# George Hotel

## Refurbishment (Planning & LBC)

### Response – VICSOC, SBH, CC and 20<sup>th</sup> C

#### 10.07.25

**2 GF Reception - Demolition Floor Plan**  
1 : 50

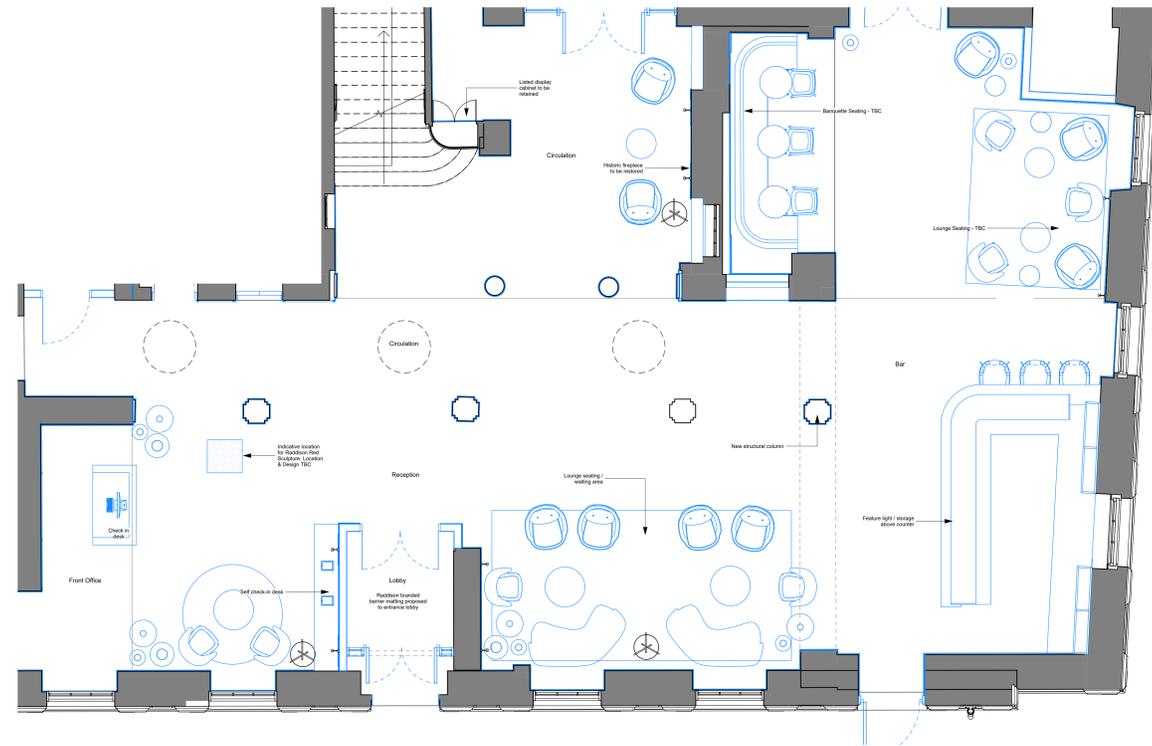
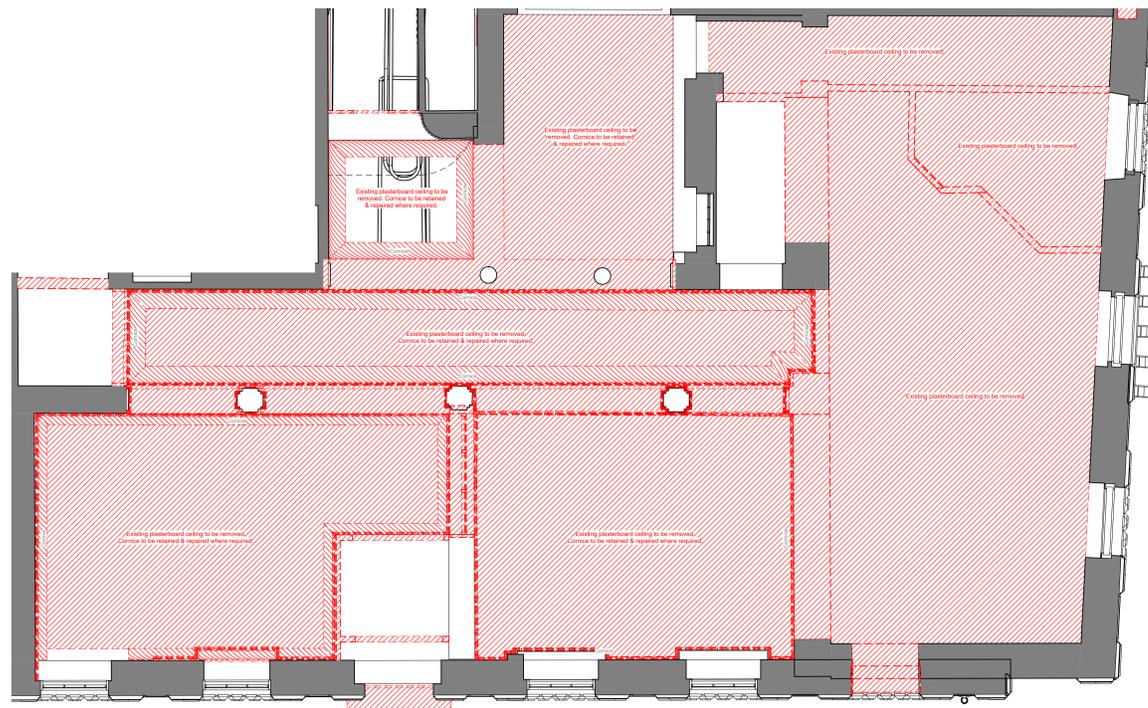
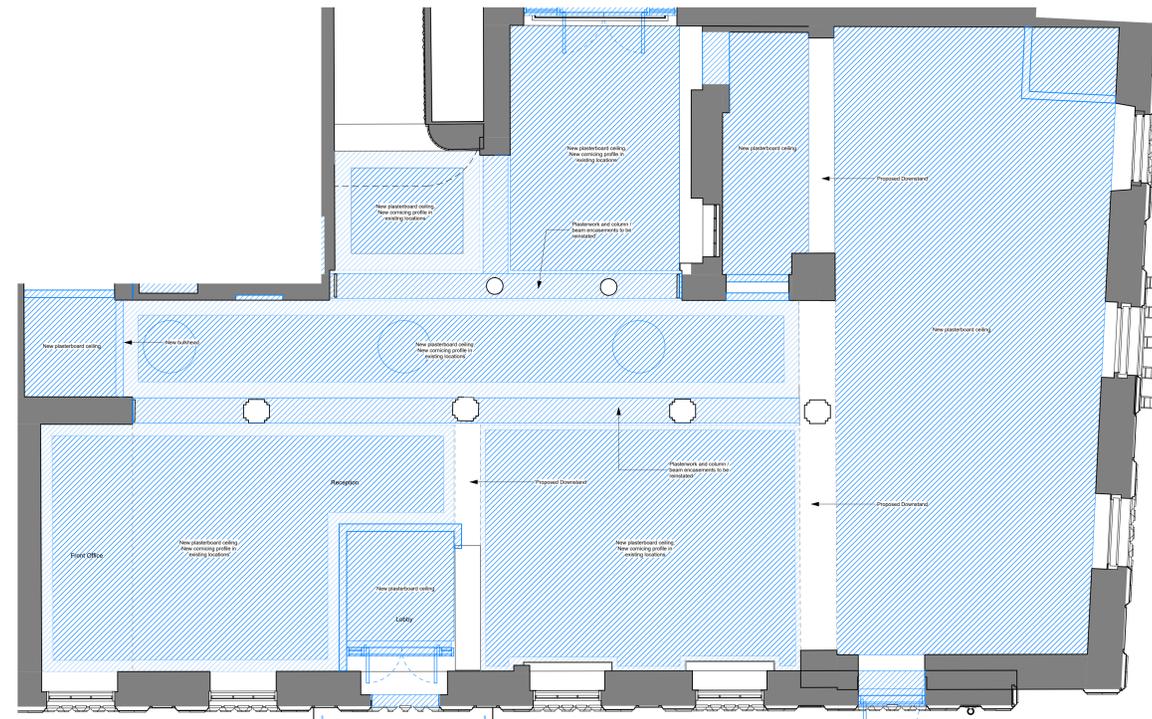
The provided Heritage Impact Assessment states at Paragraph 4.0 that 'the 20th century low quality alterations including the coffered ceiling at the base of the stair will be removed to allow better understanding of the interior spaces'. The Assessment of Significance (L054-AHR-XX-XX-RP-A-08804 P1) indicates at Part 5 (page 26) that the coffered lobby ceiling dates from the 1930s major work. The Historic England List entry for the lobby indicates that it 'survives well, with scagliola columns, decorative skirtings and cornice in Art Deco-influenced Classical style'. If this coffered lobby ceiling is part of the 1930s work, we strongly support its retention as part of a coherent and well-retained whole. The heritage significance of this ceiling does not appear to be recognised within this application. Similarly, the Interior Design Report – Concept (L054-AHR-ZZ-01-ZZ-T-I-08901) indicates that 'there are a mixture of floor tiles all believed to be a later addition' in the lobby; the Assessment of Significance states that 'there remains a black and white tiled floor in this area which appears to correspond to the original floor plan'. This tile flooring ought to be explored further. If it is a surviving feature of the 1930s work, it ought to be retained, rather than replaced with new tiling as indicated on page 47 of the Interior Design Report.

During initial works carried out as part of the initial consent has become apparent that the lobby ceilings were renewed in the 1980's refurbishment. They are a mix of plasterboard and fibreboard and of no historic merit.

It is however intended to restore and retain the scagliola columns, skirtings and cornice in the lobby areas and to restore the ceilings to the height of the 1930's ceilings and pick up on their detailing to aid understanding.

There will be no significant loss of 1930's fabric to the ceilings. The tiled floors are considered to date from the 1980's refurbishment. Their provenance is being investigated as part of the archaeological survey.

2 Former Dining Room - Demolition Floor Plan
1 : 50

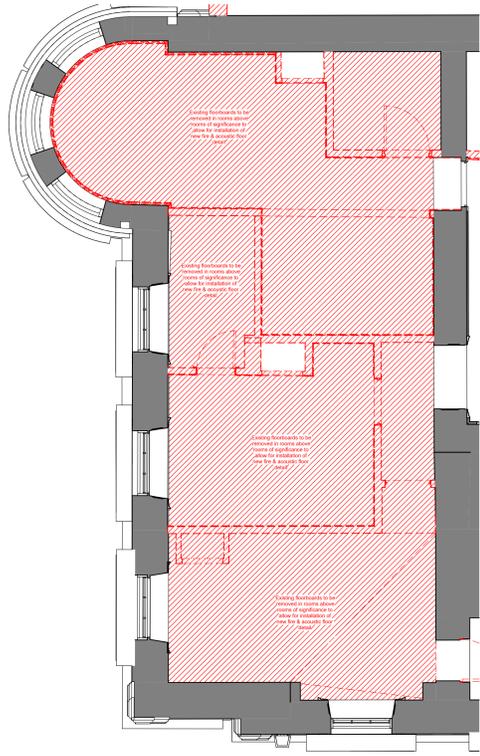
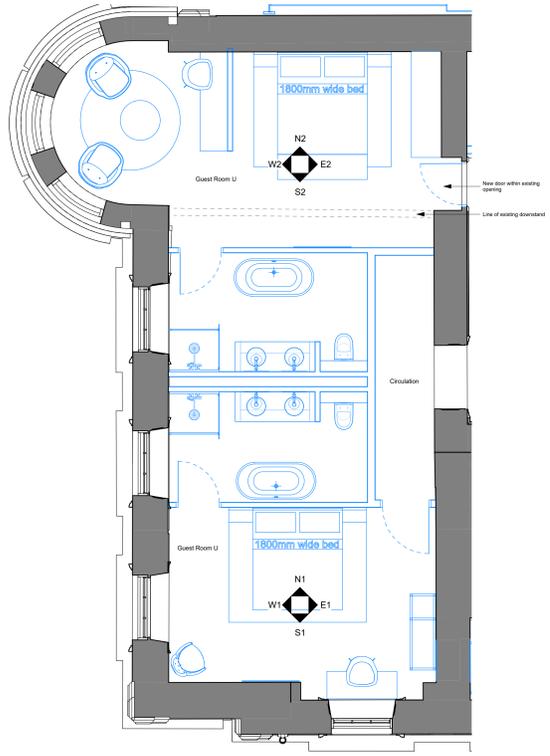
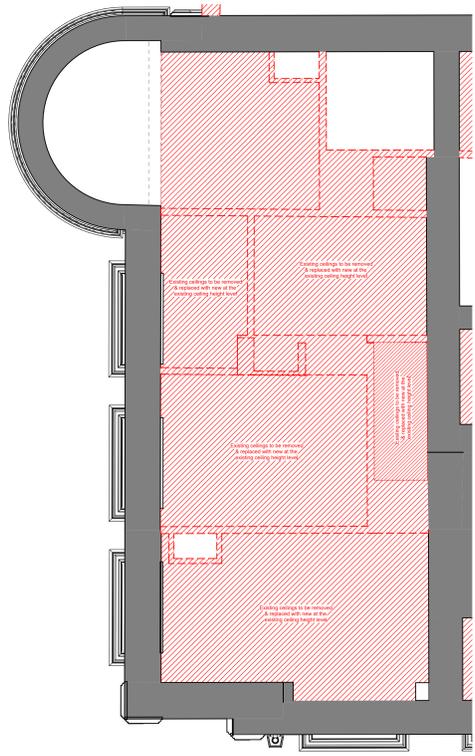
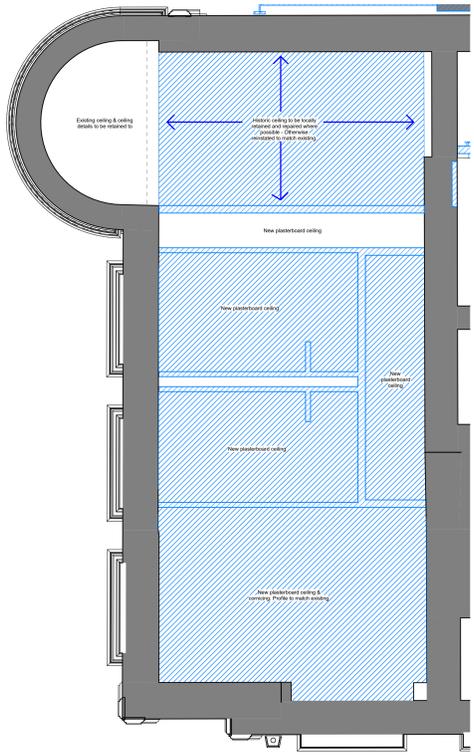
The Heritage Impact Statement states at Paragraph 2.2.3 that 'block C is much altered and considered of neutral or no significance'. Given that the Historic England List entry explicitly states that the 'ground-floor dining room of the north-east wing retains its 1930s decorative scheme which matches that of the lobby, including Art Deco glazed doors', we refute the claim that Block C has neutral or no significance.

While Historic England have decided to exclude the ballroom and the north-west wing ('Block B') from the listing, this is not the case for the dining room, and the rest of the north-east wing ('Block C'). Justification for the demolition of Block C is given in the Heritage Impact Statement at Paragraph 4.3 as due to 'the extent of alterations that have been undertaken both internally and externally and the resulting structural condition'. There does not appear to be a structural report attached to justify the demolition of this GII\* listed wing of the hotel. There is also an implication that the 1930s alterations are not of significance, when this is not the case.

As per NPPF 212, when considering the impact of a proposed development on the significance of a designated heritage asset, great weight should be given to the asset's conservation (and the more important the asset, the greater the weight should be). Given the Grade II\* listed nature of the building, strong justification must be provided for the demolition of the north-east wing of the hotel, including the demolition of the dining room. The photographs of the dining room in Part 5.2 of the Assessment of Significance appears to show it in good condition, with what appears to be original flooring. The glazed doors to both the dining room and the ballroom appear to be in-situ.

*While structural issues may be present, it is unclear if options such as retaining the dining room on the ground level, and demolishing unsound structure above, has been considered. This must be evidenced in order to justify this demolition. This section of the statement claims that 'both blocks [B&C] contain a mixture of neutral & detrimental 20th century interventions and mid to late 19th century-built fabric deemed to be of medium significance', without taking into account significant twentieth century fabric, such as the dining room. It is imperative that this high-quality, high significance twentieth century fabric is appropriately recognised as such.*

The dining room has been extensively altered in the 1980's with modern plasterwork and plywood boxing used to replicate details. Circulation routes to the ballroom and other internal features have been altered over time, reducing the evidential value of the space.

Investigations have revealed extensive late C20 alterations to both the lobby and dining room and this has impacted on their heritage value. There are structural and viability issues regarding the retention of the dining room and block C, the interiors of which have been compromised by past alterations.

It is considered that on balance the long term viability of the hotel is of significant public benefit and that this outweighs the harm through the loss of the altered interior space.
